**Reserved Matters Application including access, layout, landscaping and scale pursuant to Outline Planning Permission 14/02121/OUT for internal Primary and Secondary Streets along with the part discharge of conditions 12, 16, 17 and 19 for Phase 1B at Himley Village, Bicester**

Further to discussions with yourself and Officers at Oxfordshire County Council Highways Department I am submitting a revised scheme pursuant to Reserved Matters application 23/01493/REM for Phase 1B, Himley Village, Bicester.

TITLE  
**S278 OFFSITE HIGHWAY WORKS  
 PRIMARY ACCESS JUNCTION  
 GENERAL ARRANGEMENT  
 SHEET 1**

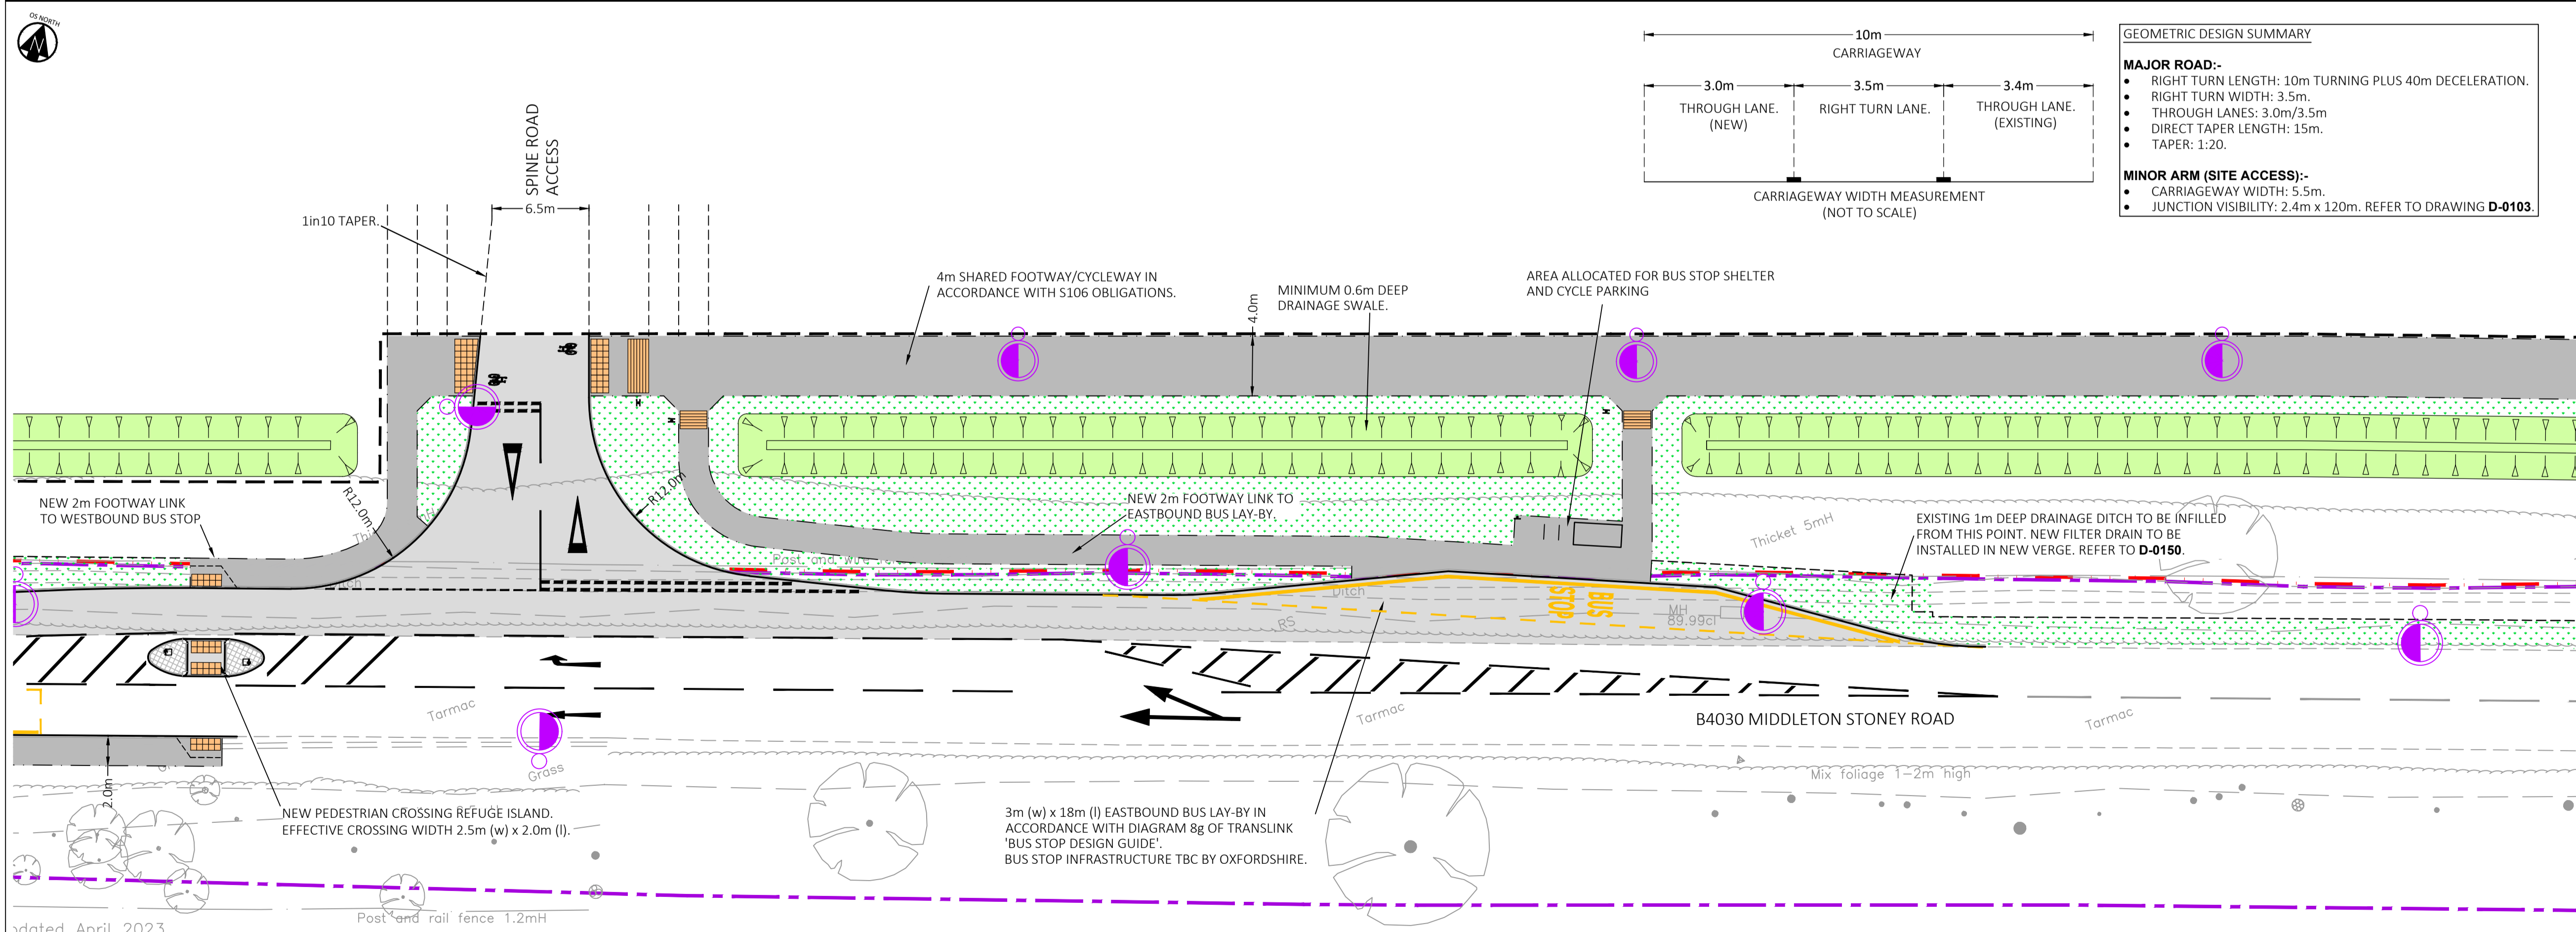
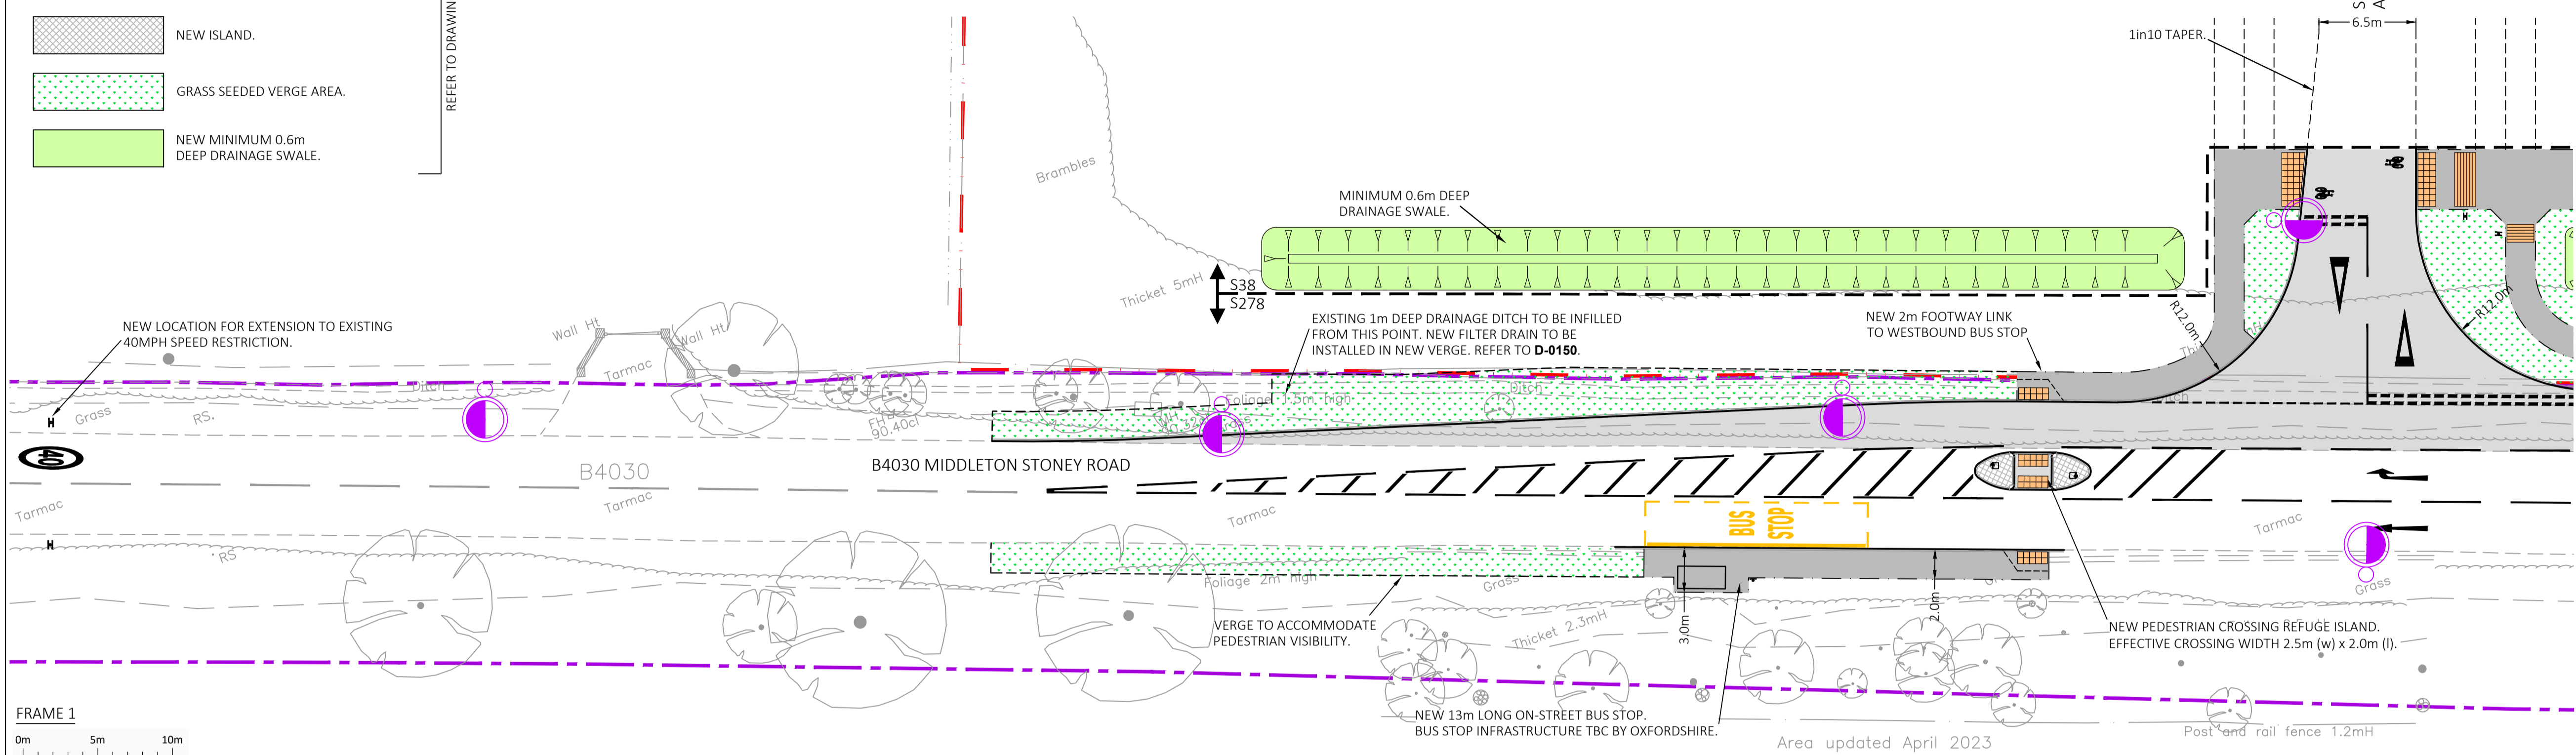
*“ATE suggested a segregated walking and cycling route along B4030 Middleton Stoney Road would significantly increase the legibility, safety and therefore attractiveness for those considering whether to walk, wheel and cycle, in line with Figure 4.1 of LTN 1/20. It appears as though a shared use facility has been retained; however the following improvements have been made.*

- *A ‘lazy S’ bend has been introduced to ensure a smooth transition between the on site 4 metre wide footway / cycleway and the off site 3 metre wide footway / cycleway.*
- *A continuous footway / cycleway has been provided at the entrance to the Secondary Street from B4030 Middleton Stoney Road with vehicles required to give way.*

*The above improvements are welcomed and supported, however it is felt the access to the Primary Spine Road would also benefit from the same priority arrangement proposed at the Secondary Street access. This would assist those joining infrastructure within the proposal site as well as future proofing connections to the west.*

A cycle priority crossing has been added across the Primary Access Road to be consistent with the cycle priority crossing already proposed across the Secondary Access Road.

TITLE  
**S278 OFFSITE HIGHWAY WORKS  
PEDESTRIAN/CYCLE LINK  
GENERAL ARRANGEMENT  
SHEET 3**

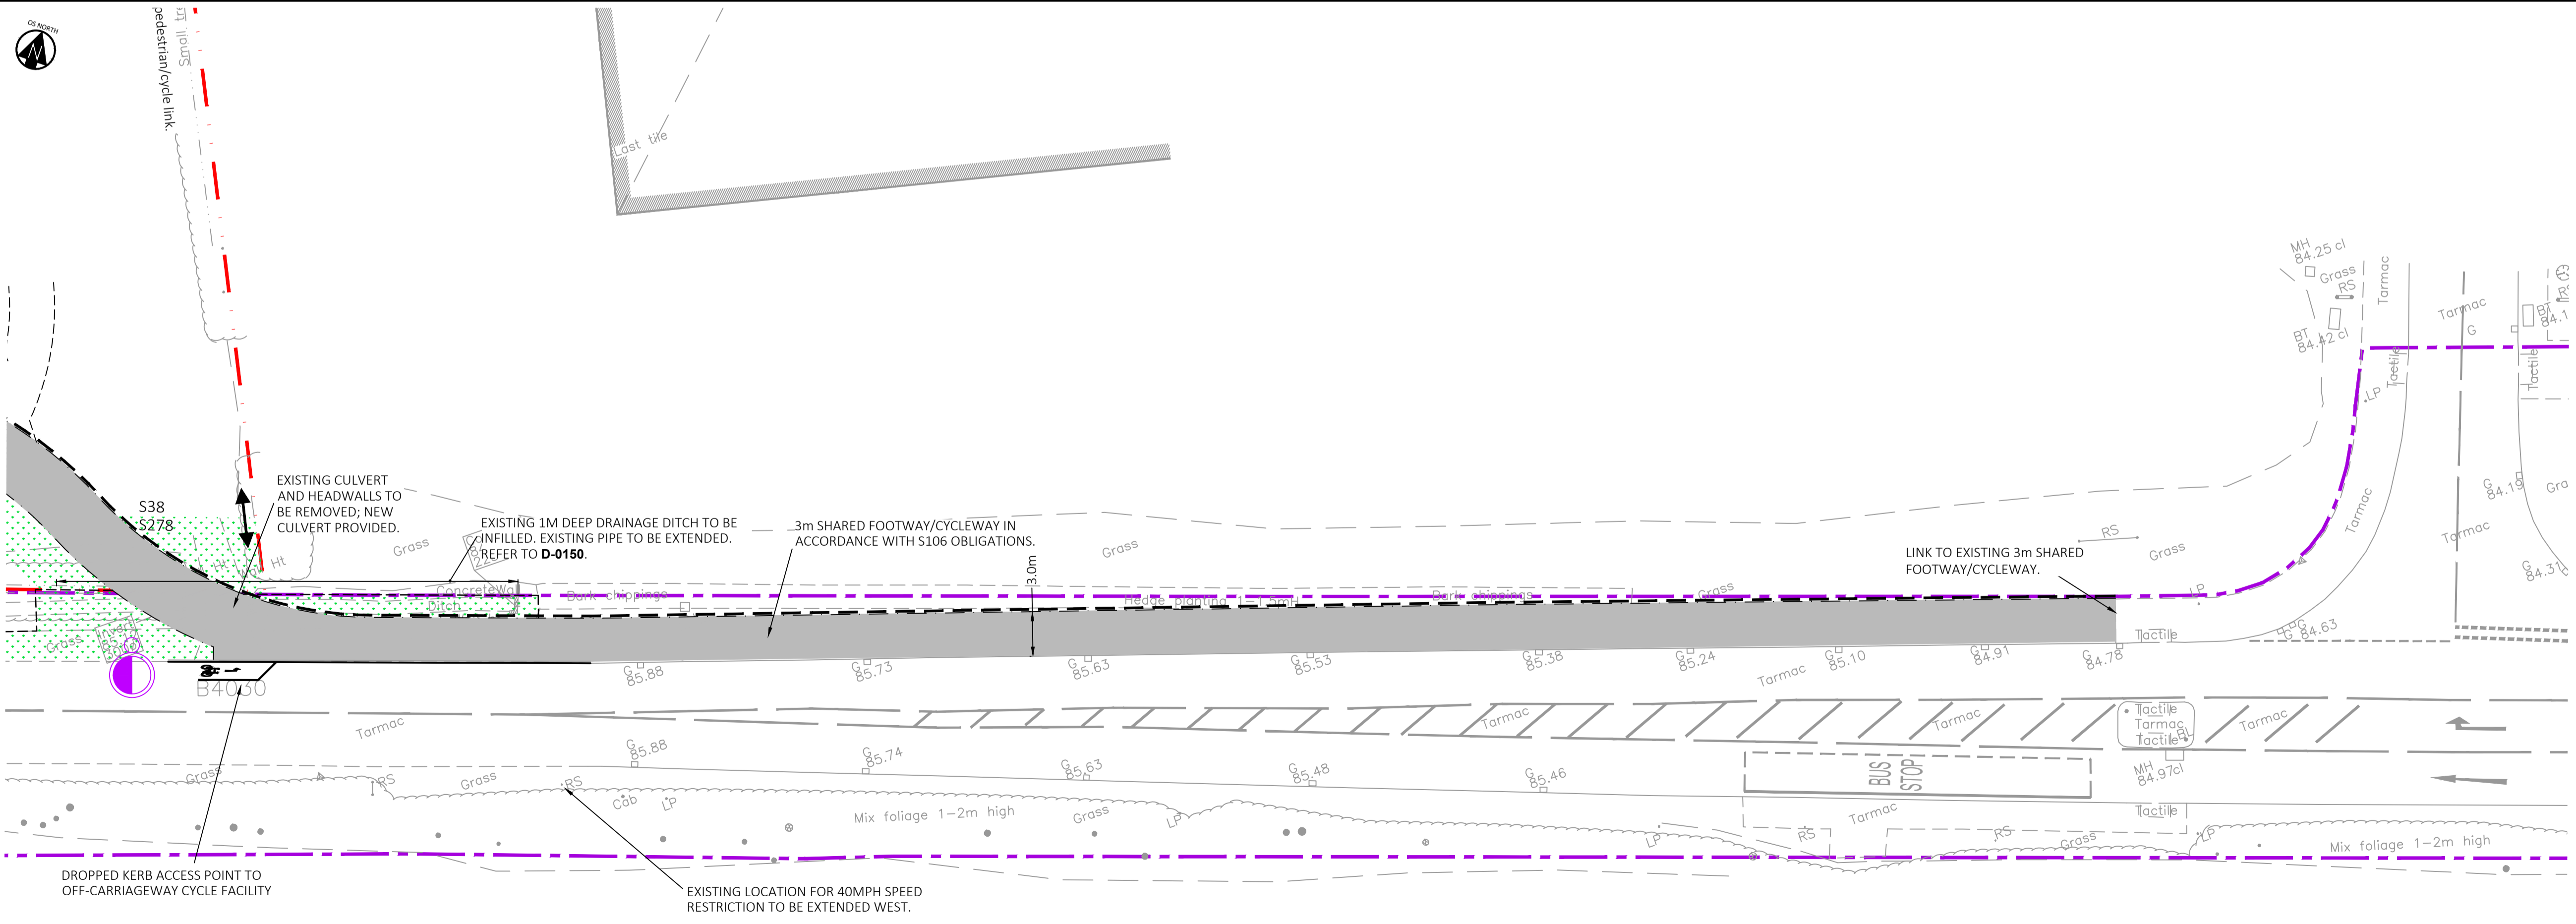
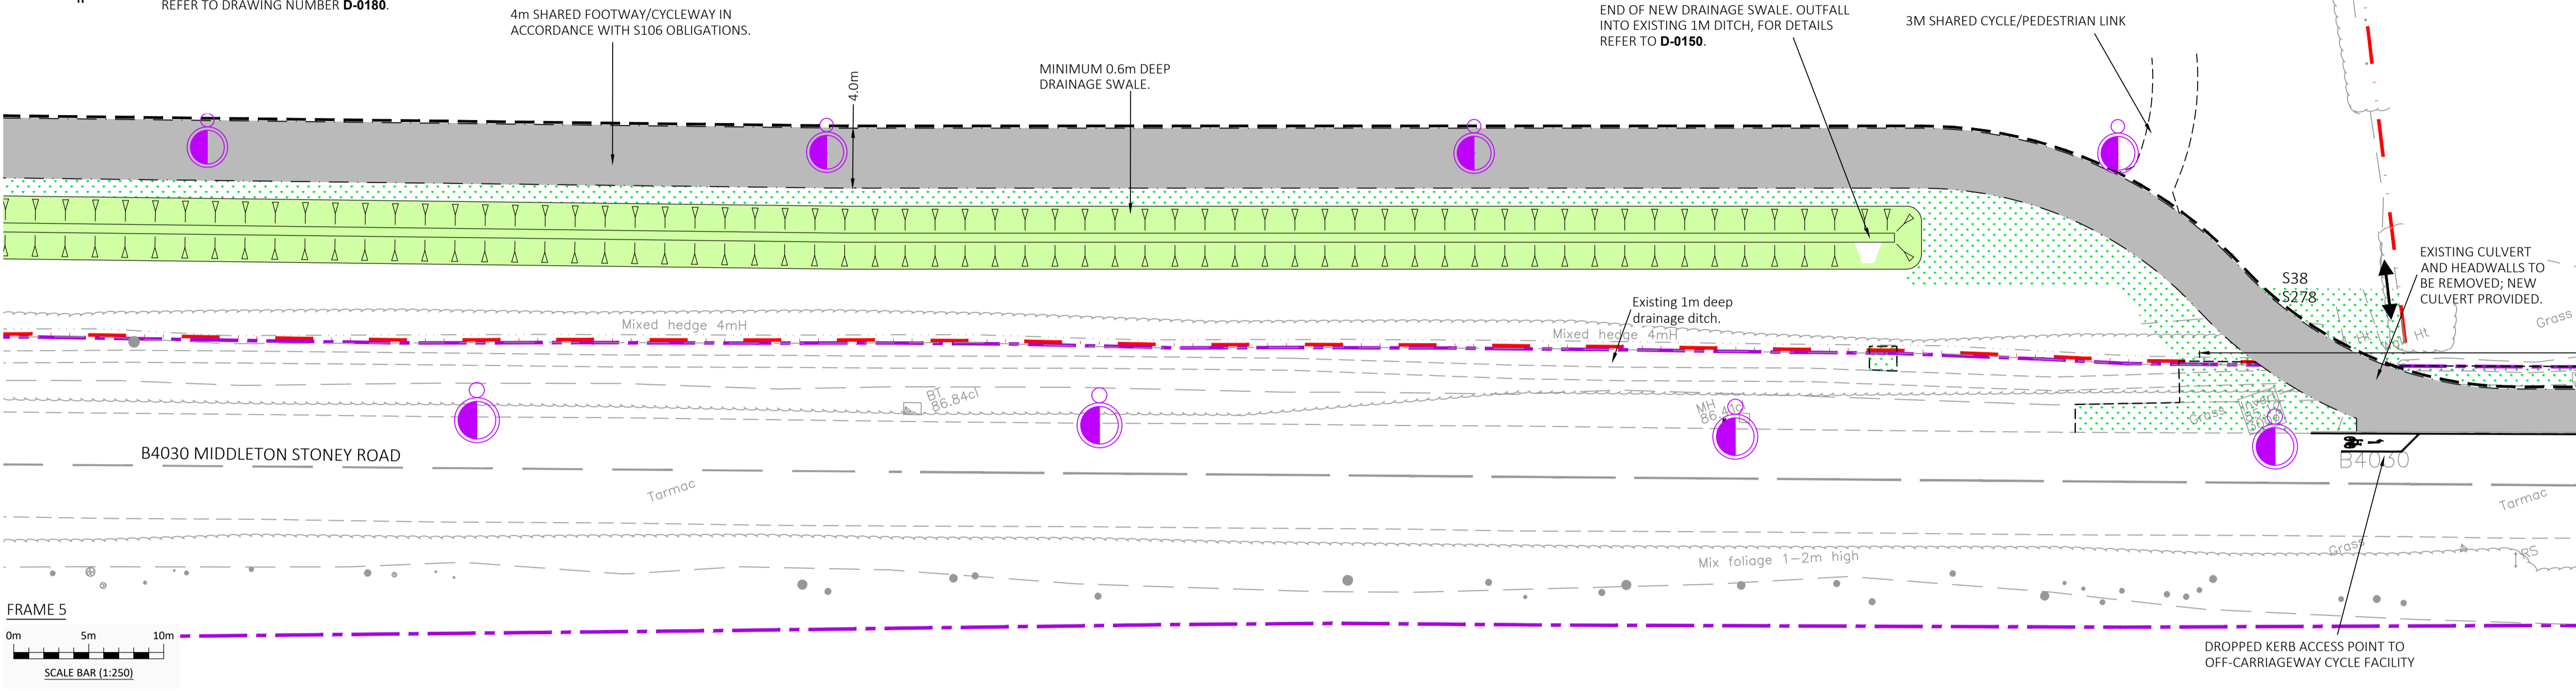
*“Access to the site requires a minimum of 1 metre horizontal buffers from the motor vehicle carriageway in accordance with LTN 1/20 Table 6.1 and OCC’s own Cycle Design Standards (3.2.7) and ideally also segregation between pedestrians and cycles.”*

*To the east of the 'lazy S' bend it is still unclear whether a buffer is to be included between the shared use path and highway."*

We believe this comment relates to the connection to the existing off site 3 metre wide shared footway / cycleway at Empire Road to the east of the proposed development. Based on Highway Record information, the width of highway land varies between 3 – 4 metres along this section of verge. Therefore, due to the land to the north being out of the control of both Cala Homes and the Local Highway Authority, Cala are unable to provide the 1 metre horizontal buffer to the carriageway. However, the proposed 3 metre wide shared footway / cycleway is consistent with the existing infrastructure that Cala will be connecting into and will provide a valuable connection between the proposed development and the surrounding cycle network.

As per the response to the BBUG comment, based on Highway Record information, the width of the highway land varies between 3 – 4 metres along this section of verge. Therefore, due to the land to the north being out of the control of both Cala Homes and the Local Highway Authority, Cala are unable to provide the 1 metre horizontal buffer to the carriageway. However, the proposed 3 metre wide shared footway / cycleway is consistent with the existing infrastructure that Cala will be connecting into and will provide a valuable connection between the proposed development and the surrounding cycle network.
